INNER WEST COUNCIL

15 May 2018

**RE: GLEBE ISLAND AGGREGATE HANDLING AND CONCRETE BATCHING
FACILITY – ENVIRONMENTAL IMPACT STATEMENT**

Figure 15 Area of identified archaeological potential (shown in red) associated with the alignment of the first Glebe Island Bridge

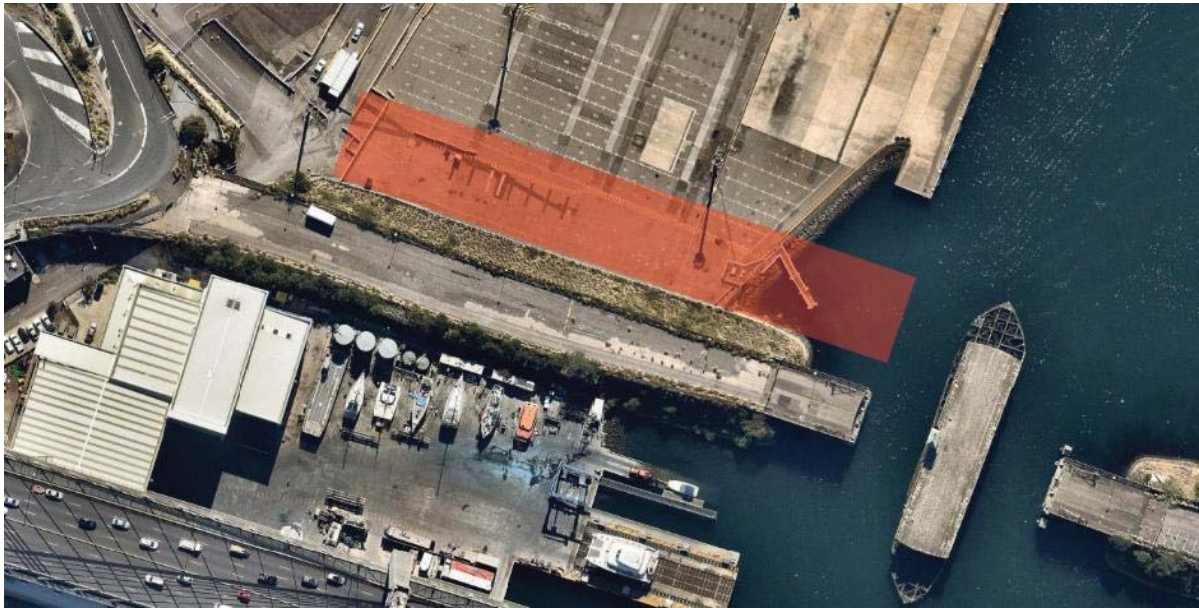
The Heritage Impact Statement (HIS) must be expanded to identify and describe the impacts on the remaining elements (including potential elements) of the former (first) Glebe Island Bridge, its embankments and potential archaeological evidence, including a site plan with proposed new structures overlaid on a drawing of existing state significant items.

The significance of the potential archaeology has not been adequately addressed. It is unclear why the first bridge has such a low level of significance in relation to the second bridge, yet both created a major route to the Sydney markets. The level of heritage significance ascribed within the HIS (Appendix C) to the former Glebe Island Bridge given its historical, technical and associational significance should be reviewed and revised.
